**Your Ref:** OWPC20983  
**Our Ref:** FG/220/18/PL 17-12-2018  
**Please ask for:**  
Andrew Wood

Erection 1 No. dwelling with integral garage.  
Land adjacent to Elm Lodge Tamarisk Way Ferring

Thank you for your internet representation made on 2nd January 2019 which has been recorded as '**an objection**' with the comments as follows:

Drawing Title **PROPOSED POND ACCESS
PLAN**

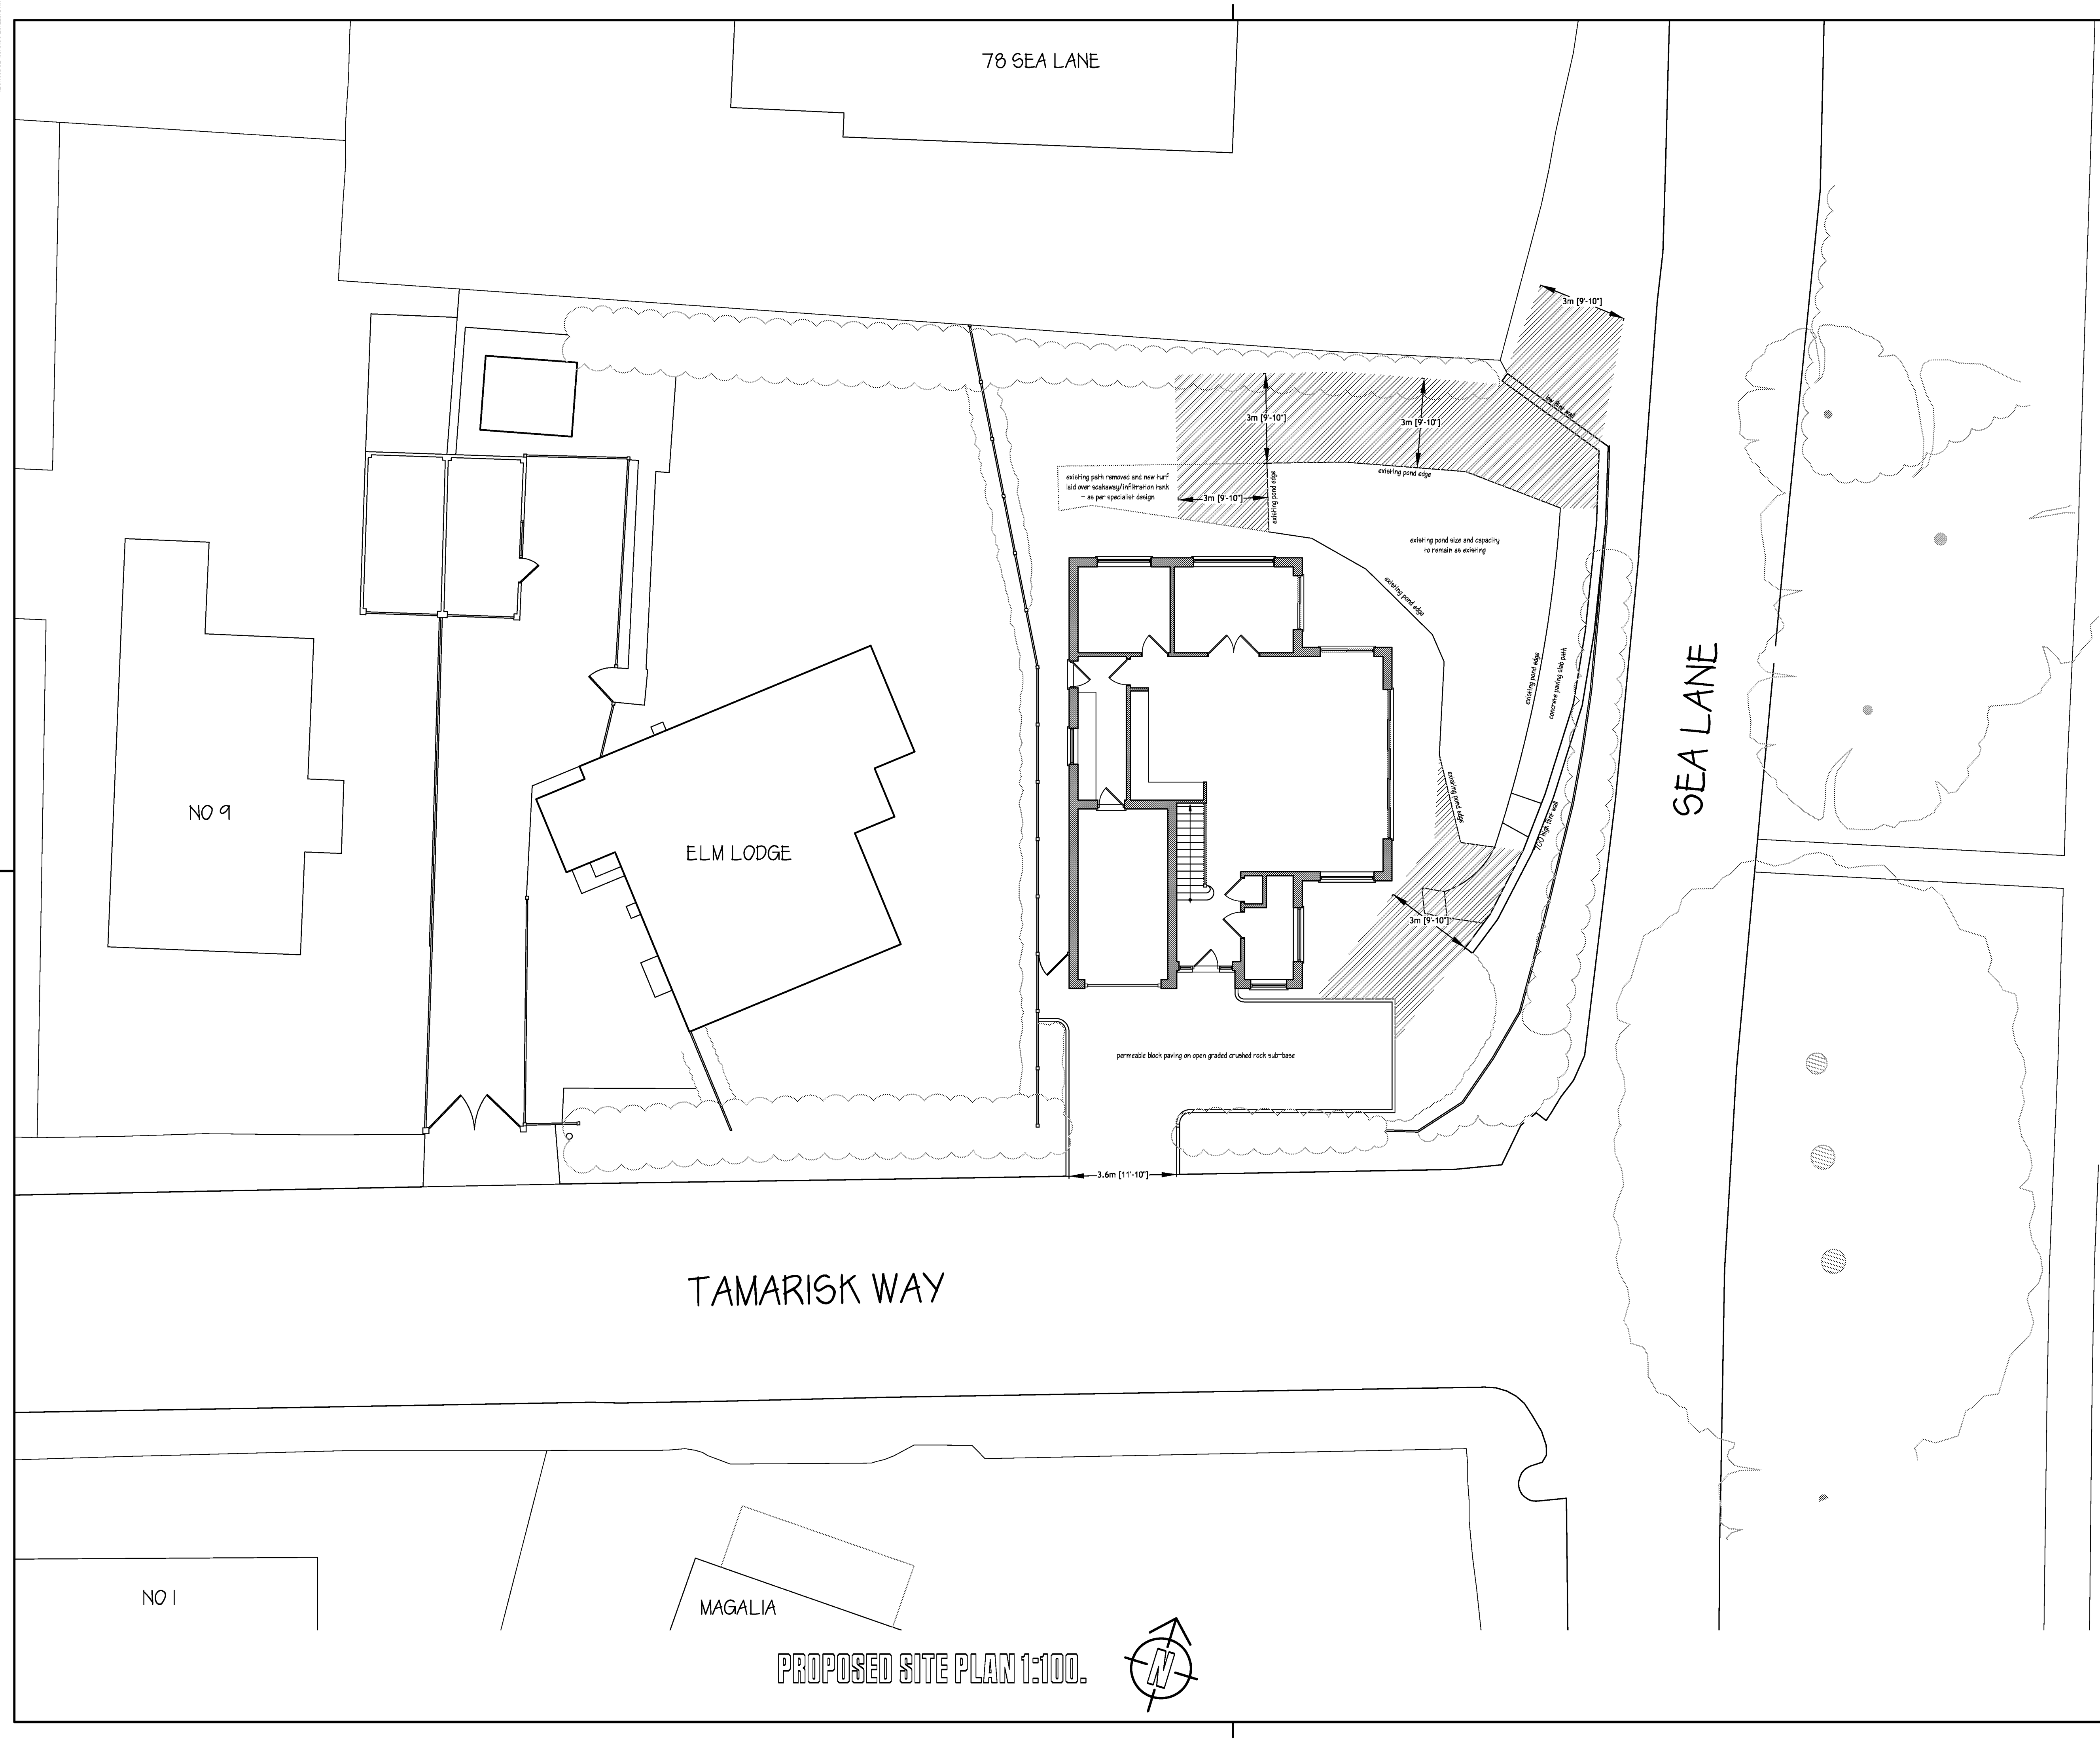
*I note in the application that the existing large garden pond appears to be retained with the property intended to be built right up to and in fact over it to provide two decking areas.*

*This is an historic pond which has been in place for many years and forms part of the important natural drainage system of the village. A culverted drainage ditch runs from it in a westerly direction across the back garden of Elm Lodge and across other properties on the north side of the road towards a similar ditch in Sark Gardens. I would have serious concerns that substantial development work here would damage both the pond and also the effectiveness of the ditch to carry water away from our properties. In addition, there is*
